# HAMMERS CONSTRUCTION, INC

## Letter of Intent

### Site Development Plan

Cathedral Rock Church  
590 Highway 105 Ste 190  
Monument, CO 80132  
Project name: Cathedral Rock Church

1 **SOUTHEAST ELEVATION**  
SCALE: 1/8"=1'-0"

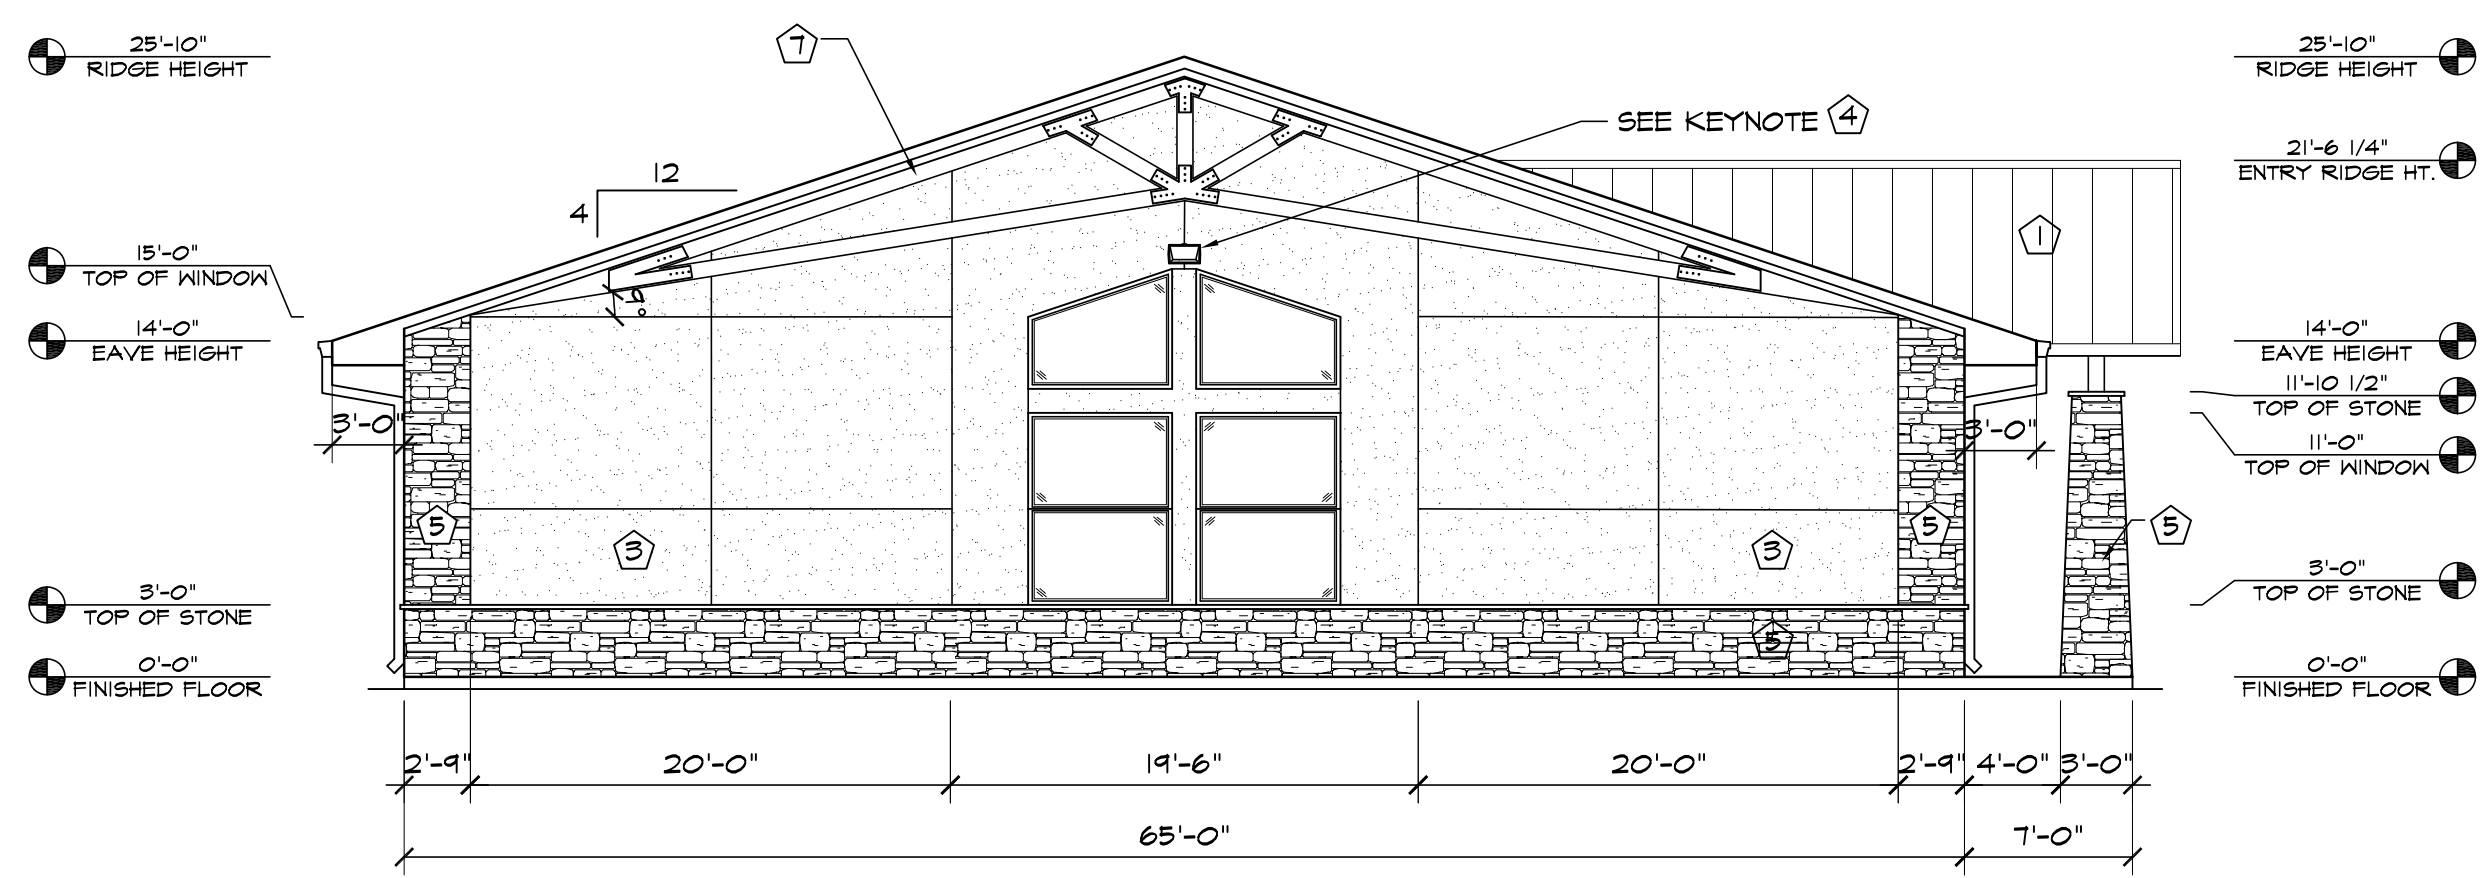
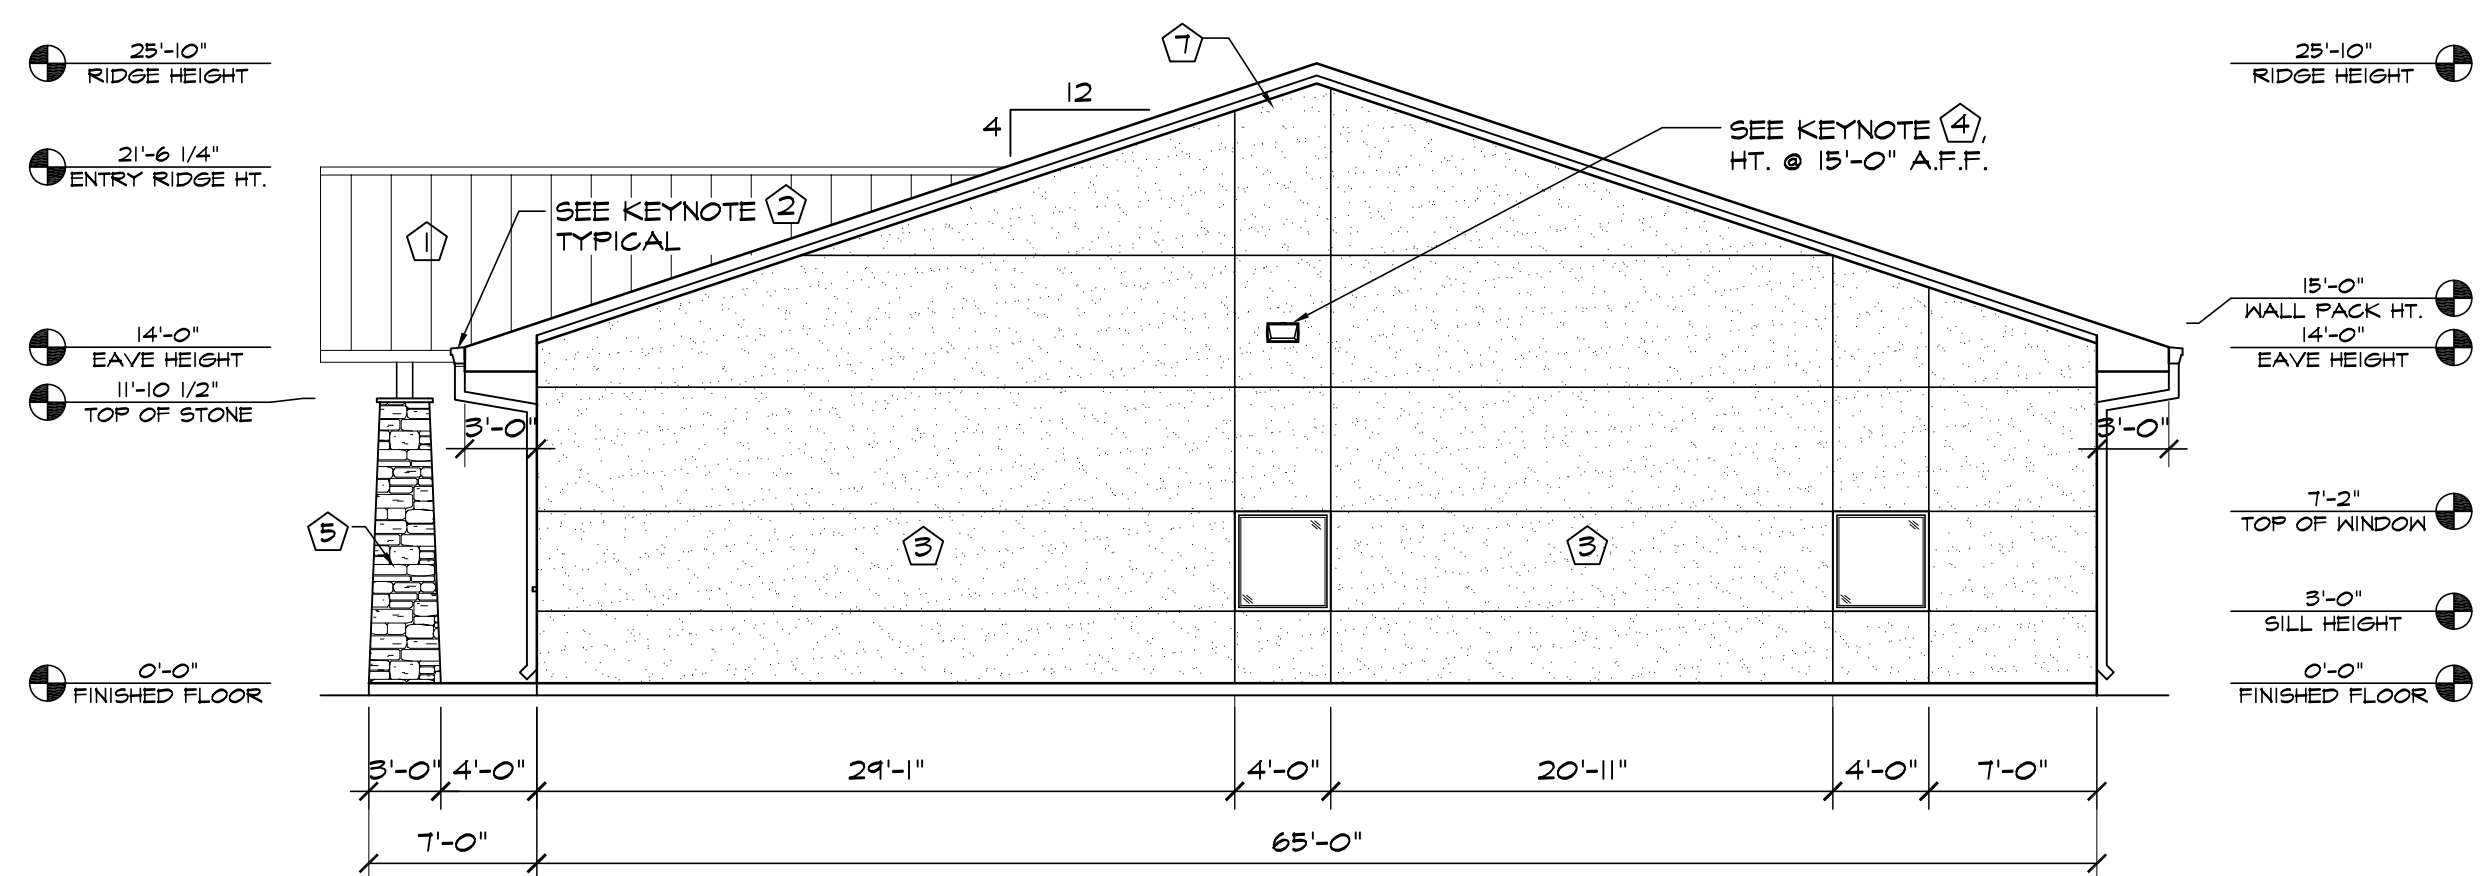
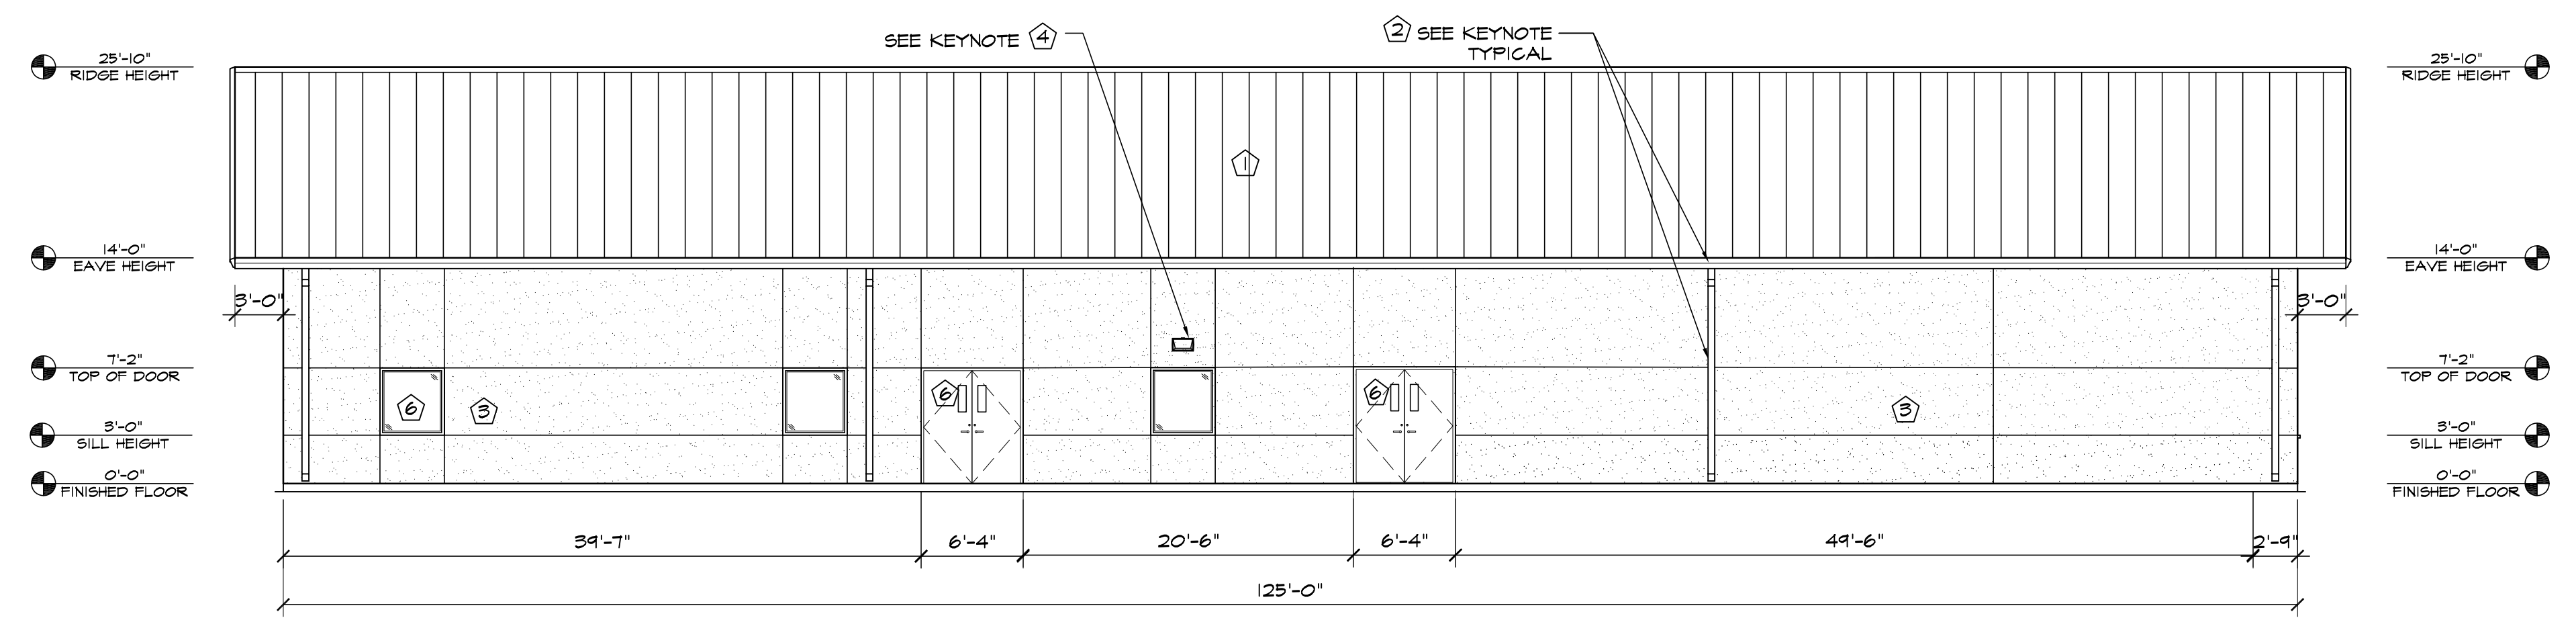
Max height 40 ft per Struthers Ranch PUD guidelines
